Application number: 2024/92317	
What is the application for?:	Outline application for erection of detached dwelling
Address of the site or building:	1, Moorside House, Moorside, Cleckheaton, BD19 6JH
Postcode:	BD19 6JH

Drawing Title
DETACHED 2 BED
BUNGALOW

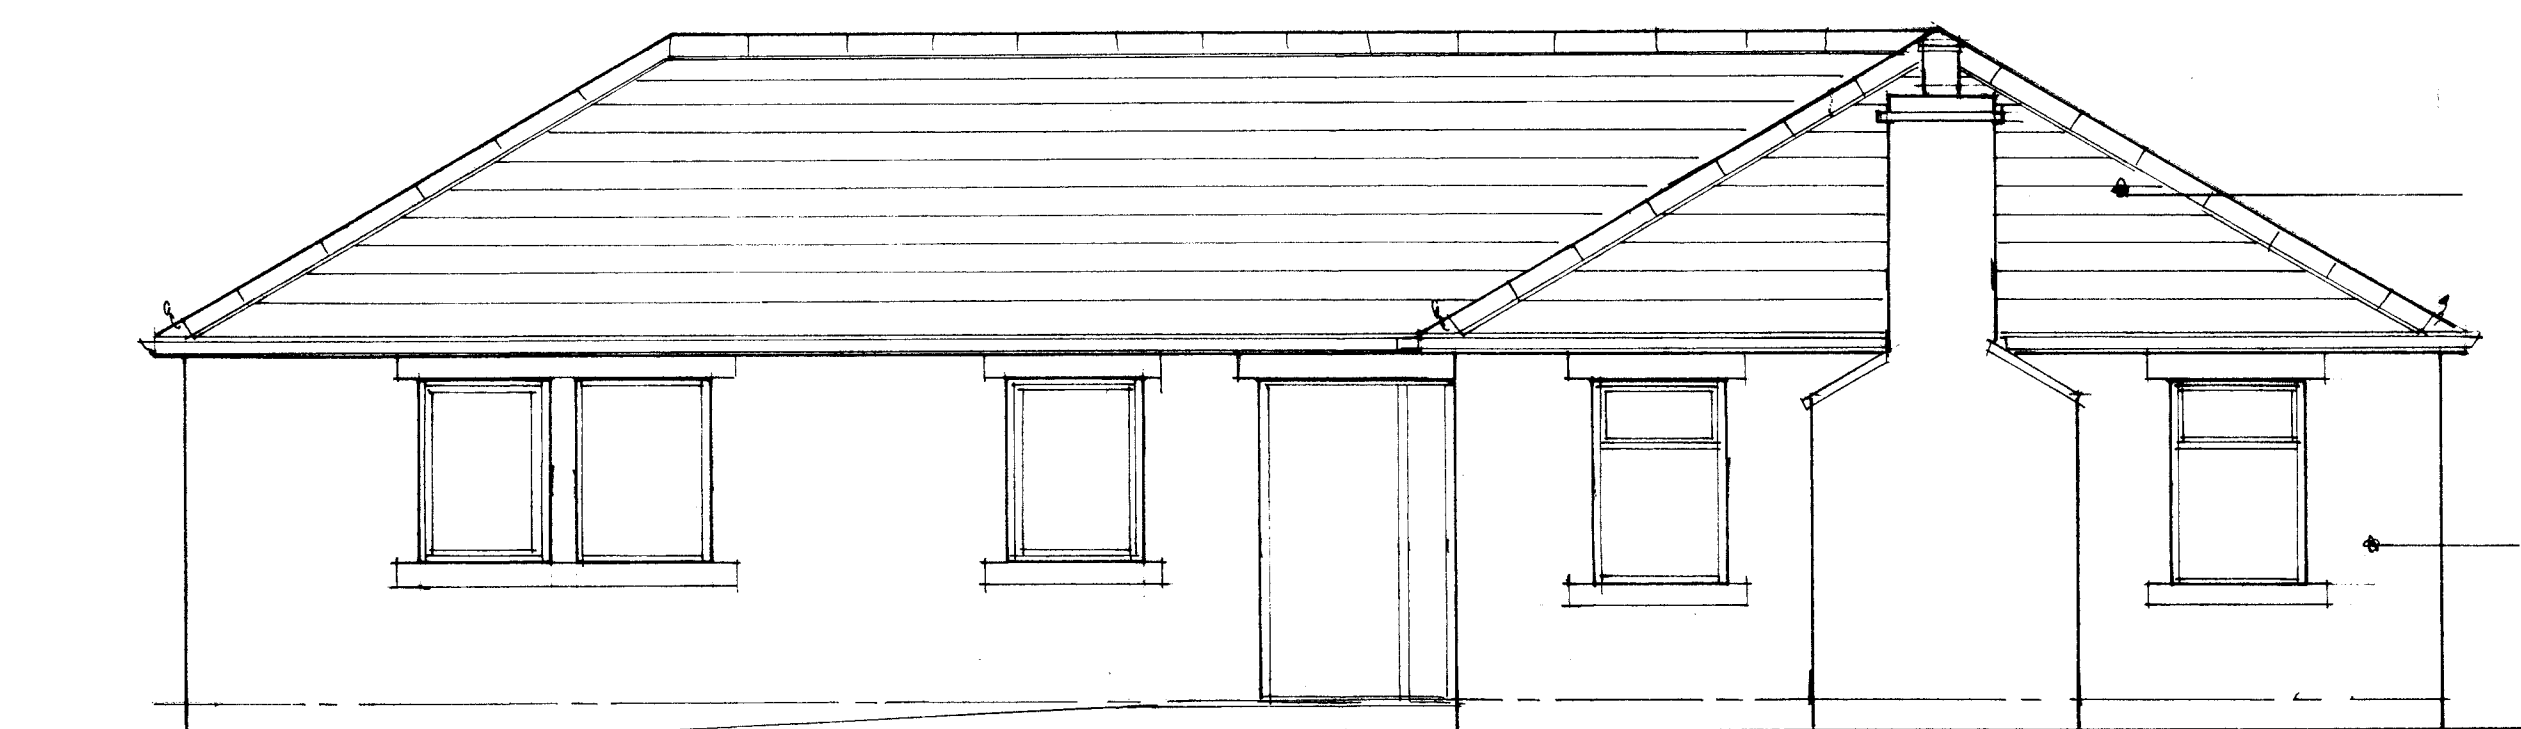
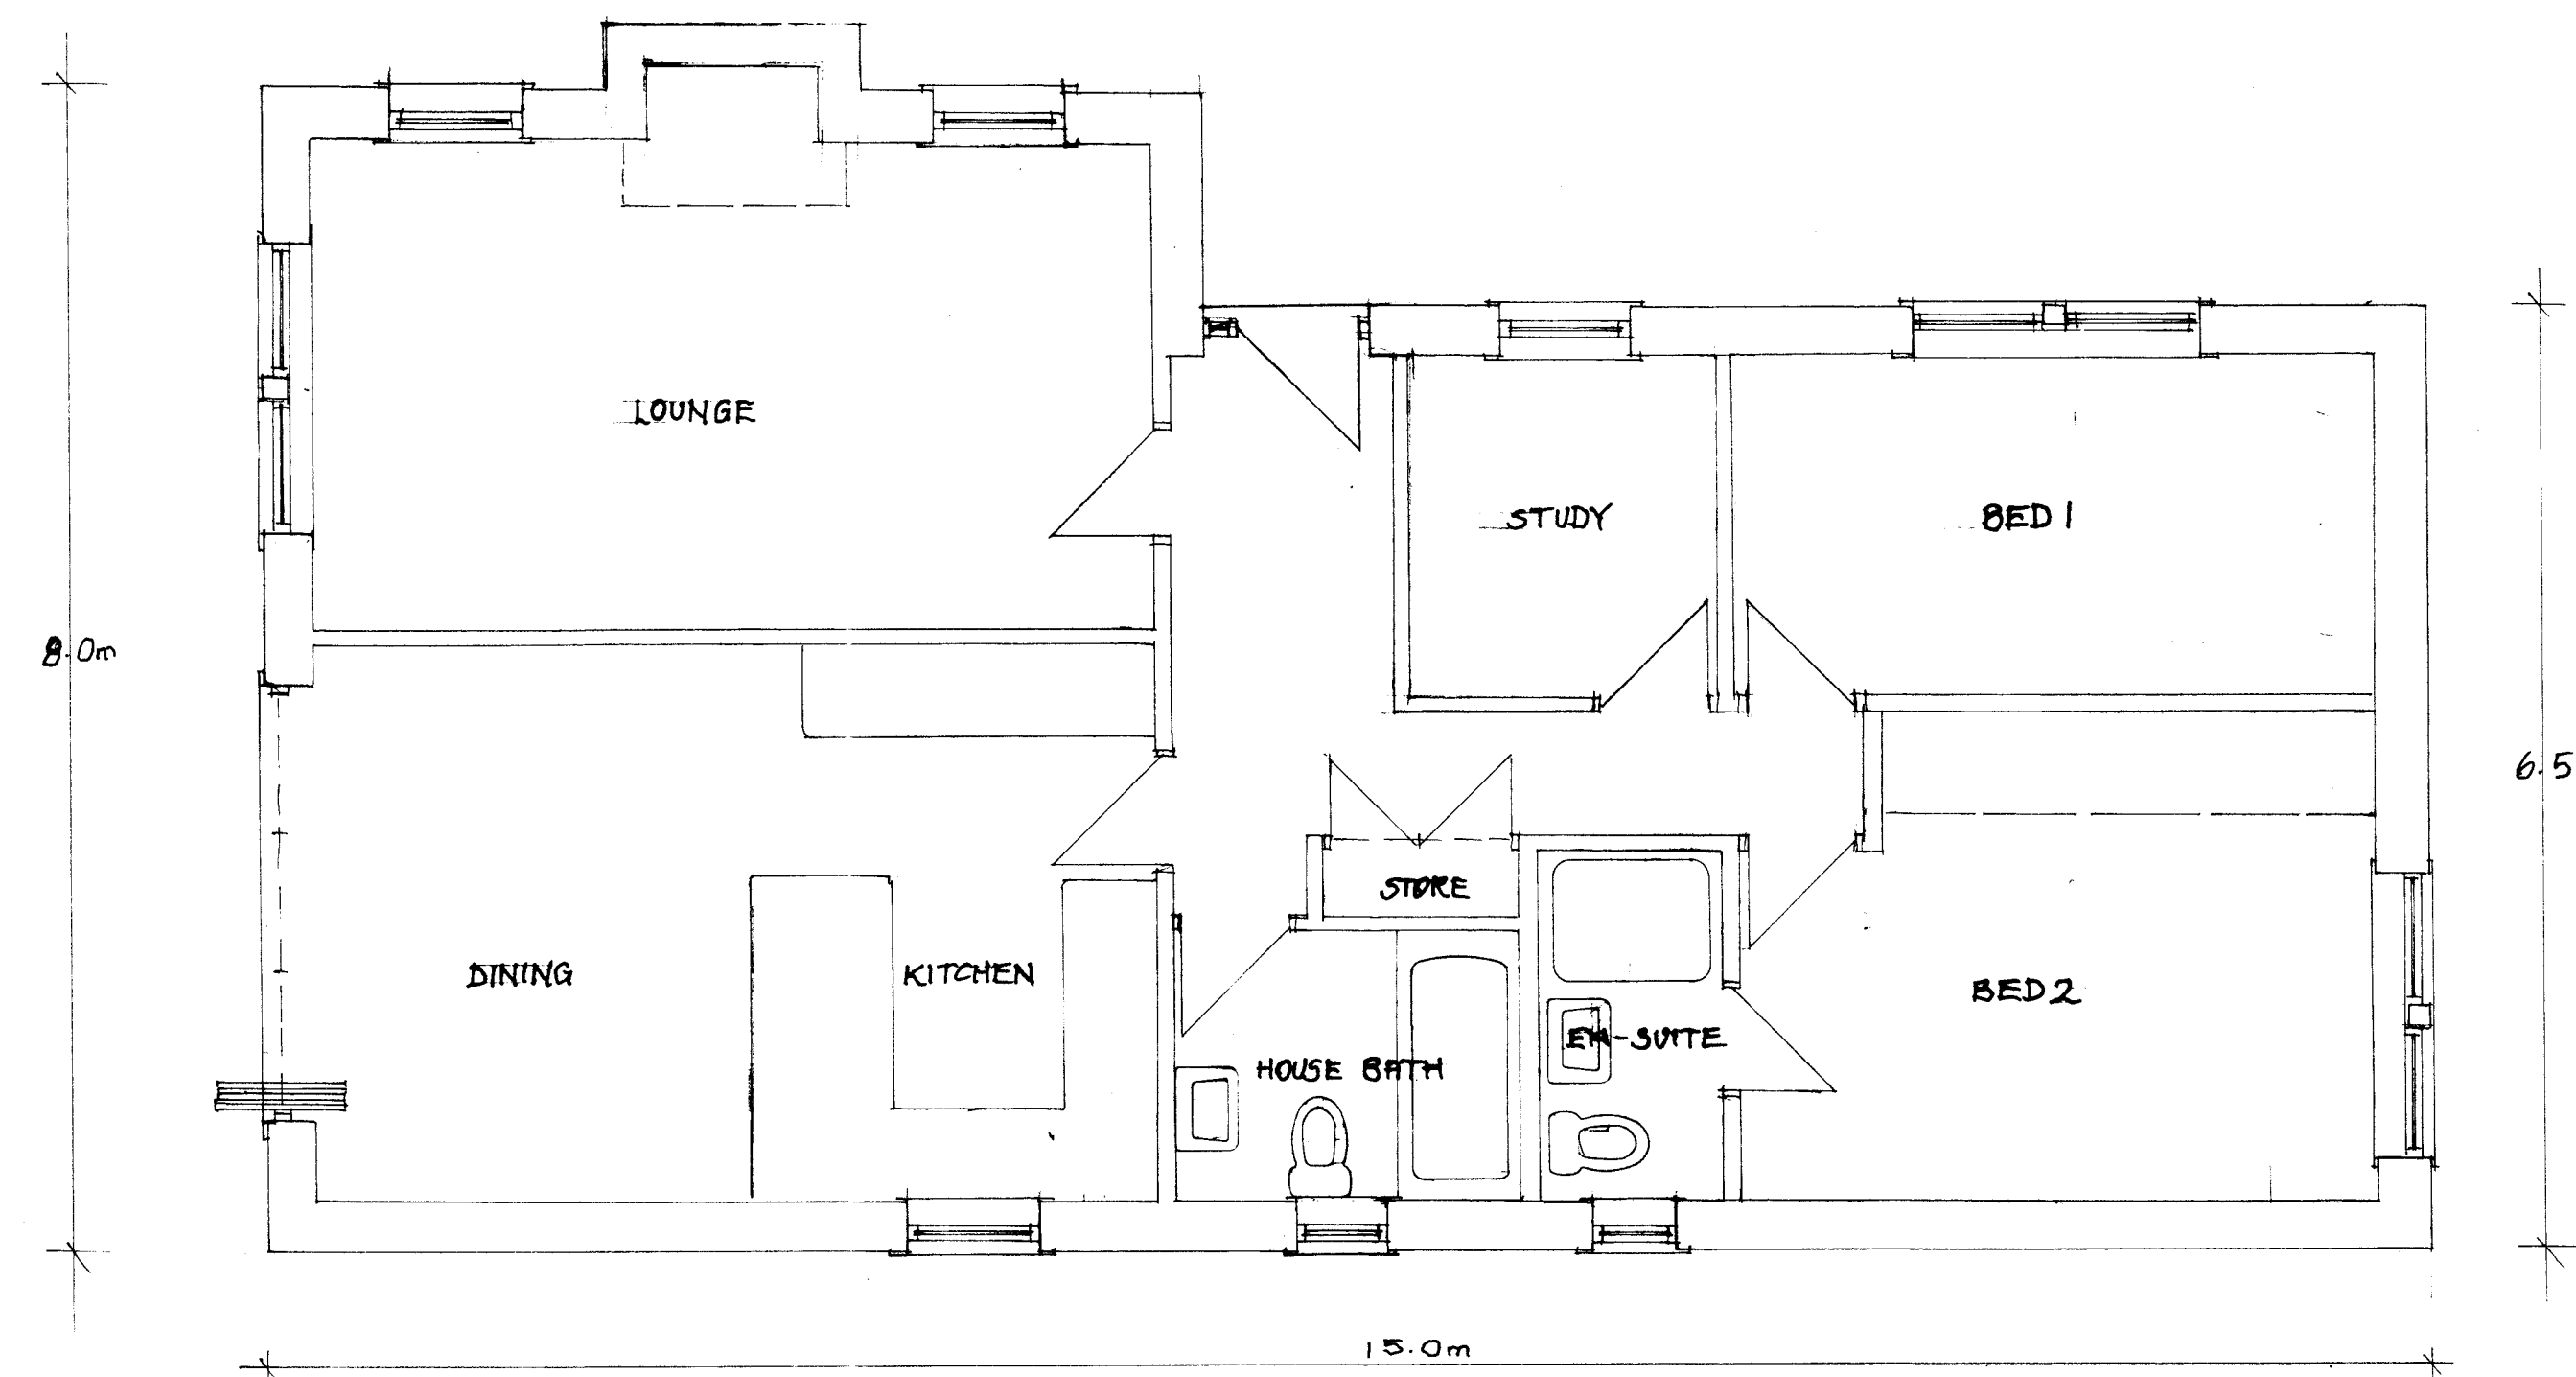
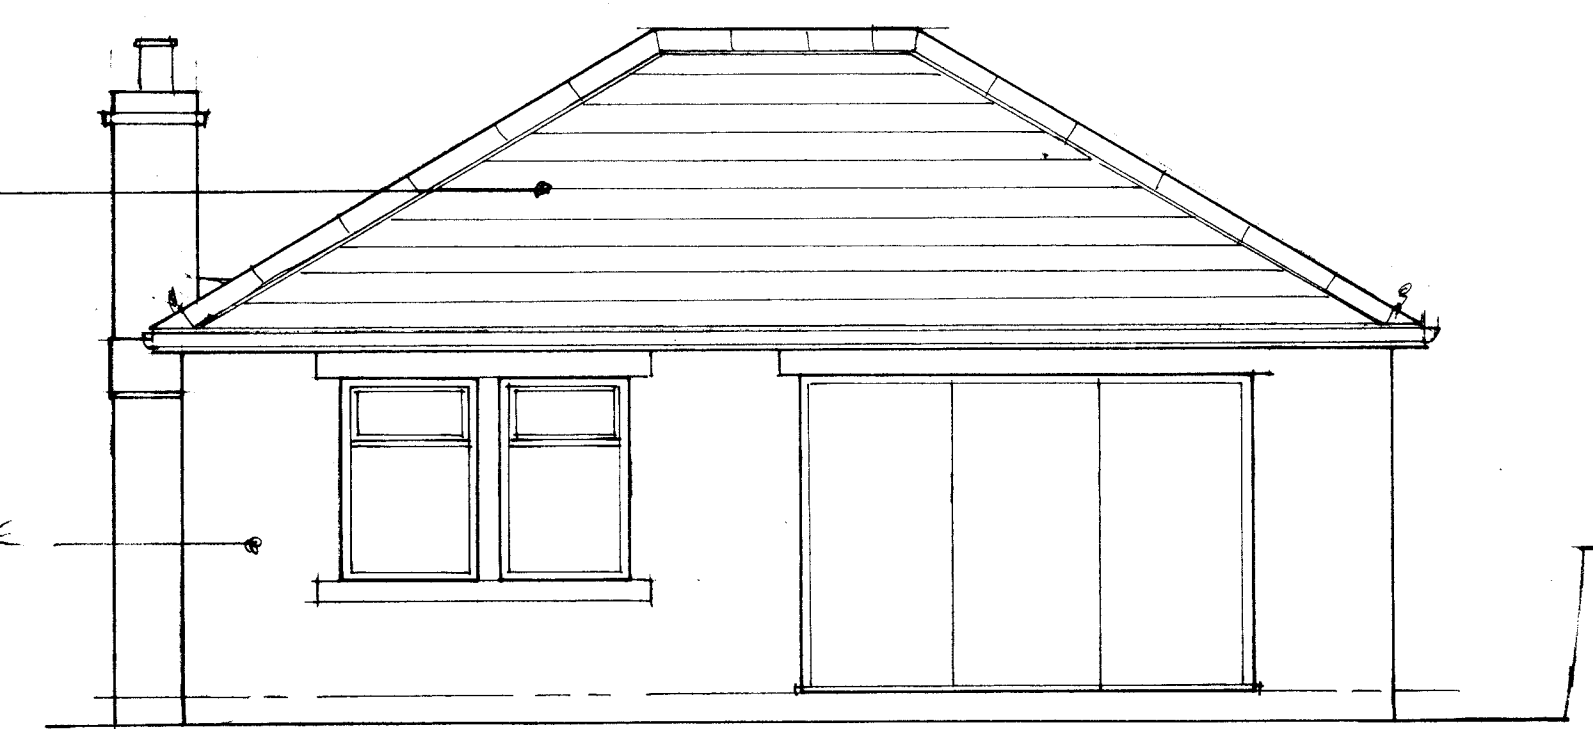
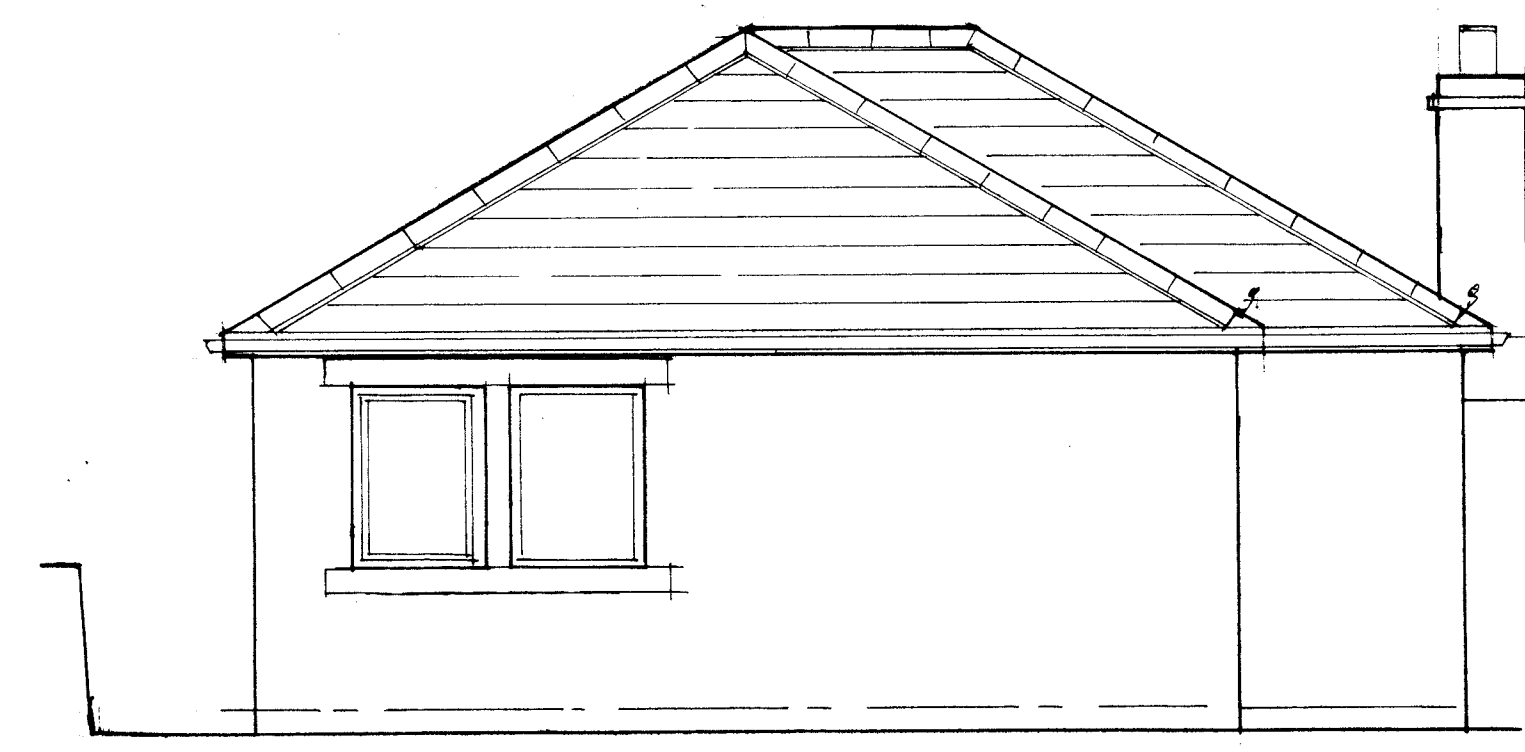
Type of comment: An objection	
Do you wish your comments to be published on the website anonymously?	No
As I live behind where this bungalow is to be built, I do have some reservations regarding this proposal. Primarily the removal of the trees that currently run along the boundary between the properties on Ash Grove and where the bungalow is to be built. These trees are well established and add to the character of Ash Grove and the area as a whole. They offer us protection from the elements, greater security to the area and a wonderful view, the removal of the trees are something this application does not mention in both the design and access statement and climate change statement. I also feel that the application does seem to be trying to fit a square peg into a round hole, there doesn't seem to be much room for a garden, parking and the bungalow itself will be long and narrow and will stick out as it will not fit into the aesthetics of the other properties in the area.
